From:
To: [DCAdmin](#)
Subject: FW: Kirklees Council: Bradley Villa Farm and Redrow Housing Application: Objection to application 2021/92086
Date: 07 July 2021 12:26:01

I have outlined our concerns below regarding the submitted planning application for proposed houses on Bradley Villa Farm:

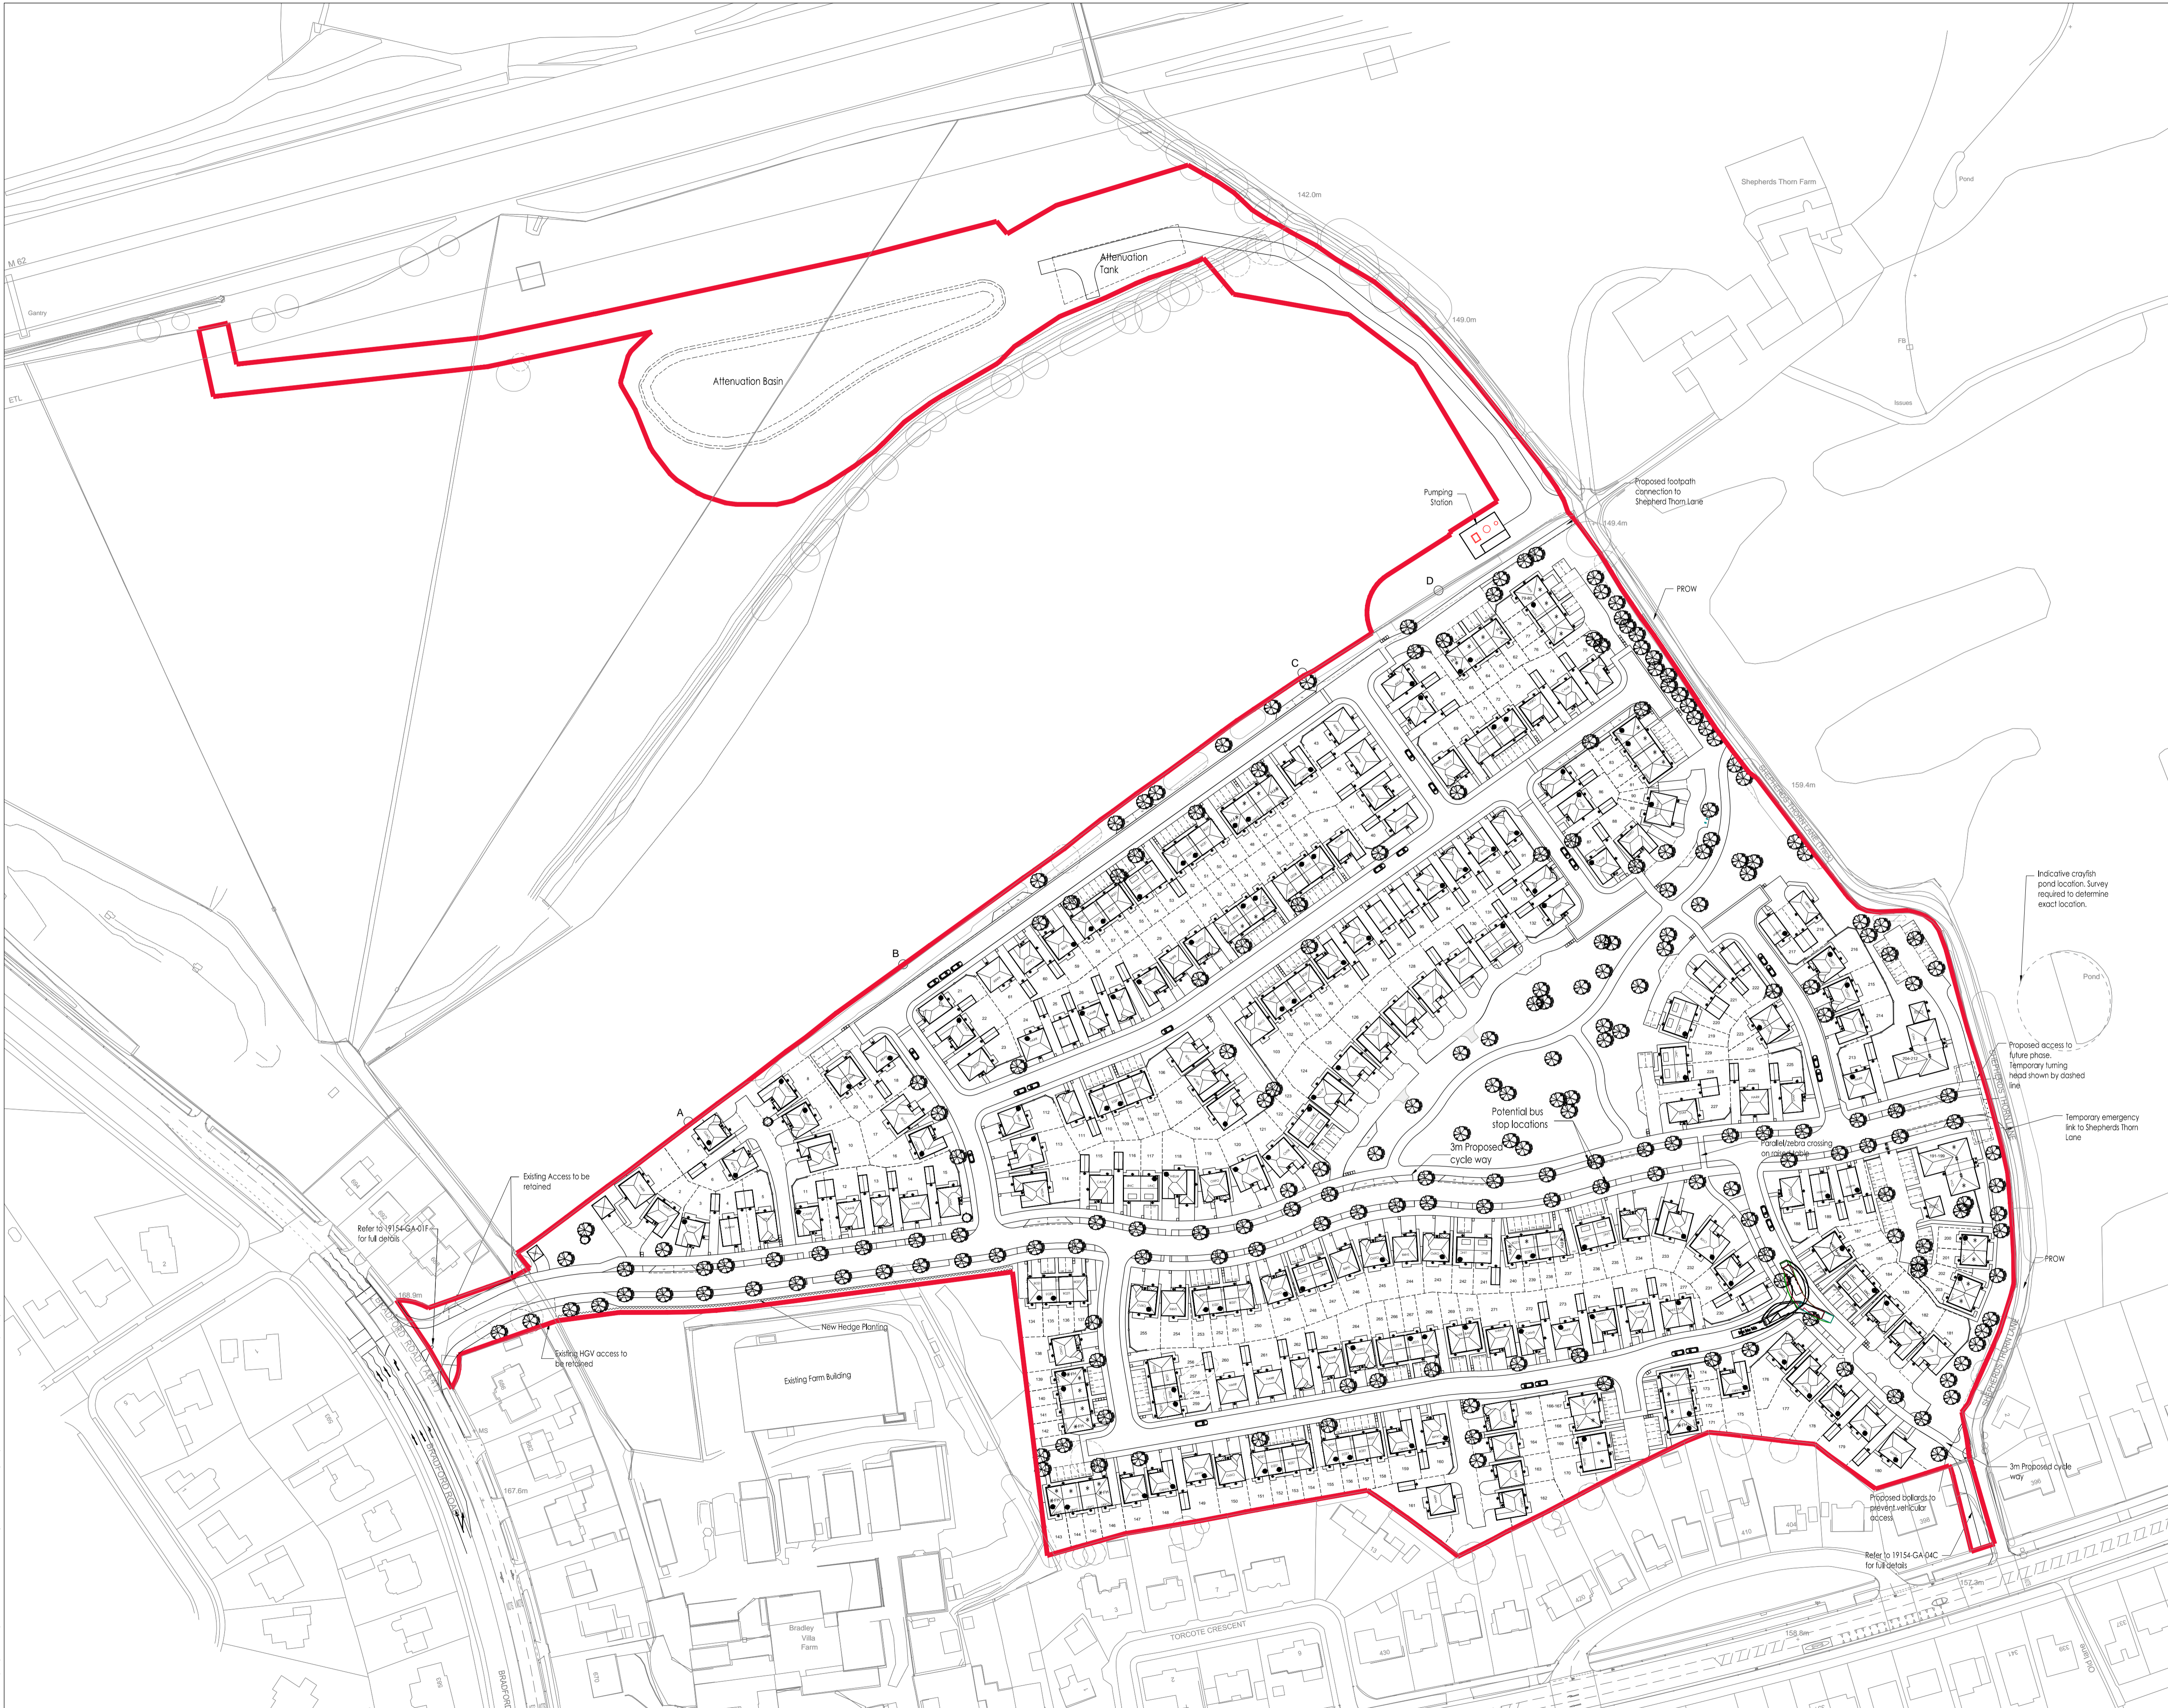
There is no detail as to how it is proposed to alleviate the flood risk to the access road to the two properties off Shepherds Thorn Lane. Details submitted show houses built into the 90-degree corner at the bottom edge of the field. This corner ALWAYS floods with collected water from the rest of the field which then overruns onto the lane resulting in damage which could possibly be made worse once the proposed road along the current field boundary is constructed, plans should make provision for draining this area and ensuring there is no risk of run off to the Lane. There is reference and a plan showing a pumping station, it is unclear if this is for surface water or foul water from the houses. It is also unclear where the access to the pumping station is. The plan indicates two possible access points, the first off the new estate. The second from Shepherds Thorn Lane – we object to this access point. There is no reference to the noise or potential smells from this station. Please can you confirm an impact study will be made and submitted for approval.

Adjacent to the pumping station a proposed footpath connection to Shepherds Thorn Lane is shown. Please can you advise how access will be planned so as not to add a security risk for the two properties already in the vicinity. This proposed access will give burglars and thieves a quick access to the bridge over the motorway. The footpath accesses the golf course further up the lane, there is already an issue with walkers accessing the private land in front of our properties looking to gain access to the golf course path, which will be further increased with the building of 200+ houses.

Plans show a proposed access/link road to the future phase across Shepherds Thorn Lane to proposed houses on the current Bradley Park Golf Course. This link road should not be constructed. It will create a rat run from the dual carriage (access point to the application site) through to Lower Quarry Road and through to A62 Huddersfield Road as indicated in future plans. By travelling along this road, drivers will be able to avoid one roundabout and three sets of traffic lights! Sat Nav's will pick up the road as quickest route for all traffic. The road will not be wide enough to cope with this amount of traffic due to homeowners parking outside their homes. I find it remarkable that this has been put forward as a proposal especially when the A62 Cooper Bridge traffic alleviation scheme is looking to change the access to Bradley Road from the A62. The proposed road access from Lower Quarry Road is due to be retained as is, it is extremely unsafe as drivers often turn right towards Huddersfield and there is no proposed central reservation to stop this happening in future on the plan. It would be safer to have the Bradley Villas site as one estate with the proposed Bradley Golf site as a separate entity. Utilities could be shared and/or extended across the public right of way that is Shepherds Thorn Lane without affecting the character if required. The multiple access points to the phases should be constructed elsewhere on the sites and not dissect Shepherds Thorn Lane, further objections are indicated to this below.

If the authority is minded to approve a proposal to build the proposed new road across Shepherds Thorn Lane, then further consideration and regard needs to be taken as to how it is intended to stop homeowners from parking on the PROW and using it as an extension of their parking areas. Clear boundaries and conditions should be attached to ensure that owners cannot build access gates onto the lane. There needs to be clear plans proposed and approved as to how traffic will be stopped from using the lane to enter or exit the housing estate to stop walkers and those with rights of access from being inundated with excess traffic looking to avoid Bradley Bar Roundabout by using the estate as a rat run. The lane is classified as an adopted all-purpose highway to bridle way standards and maintainable to those standards. However, Kirklees Highways Department have not maintained the lane in any form in the last 30 years. The lane is not suitable for a steady stream of traffic. It should also specify how it will stop cars from parking on the lane blocking the right of access.

The proposed lane for future access to the adjoining site should also be removed entirely as it destroys the heritage aspect of the site. It cuts through both the approach to a listed building and the high significance area as noted in Fig 5 of the Heritage Impact Assessment. It goes against the Kirklees Local Plan and the Heritage Assessment Plan. Shepherds Thorn Lane should be retained in its current form to ensure that no damage or impact to the highly significant approach to the listed building. This current planning application disregards the Kirklees Local Plan especially the Heritage Impact assessment.

Permission should not be granted as is currently proposed as layouts proposed clearly do not accord with the adopted Kirklees Local Plan. The heritage assets should be protected as indicated in the adopted plan. The layout should be redesigned reflecting the protection of Shepherds Thorn Lane and the heritage asset. The proposed link road should not cross Shepherds Thorn Lane.
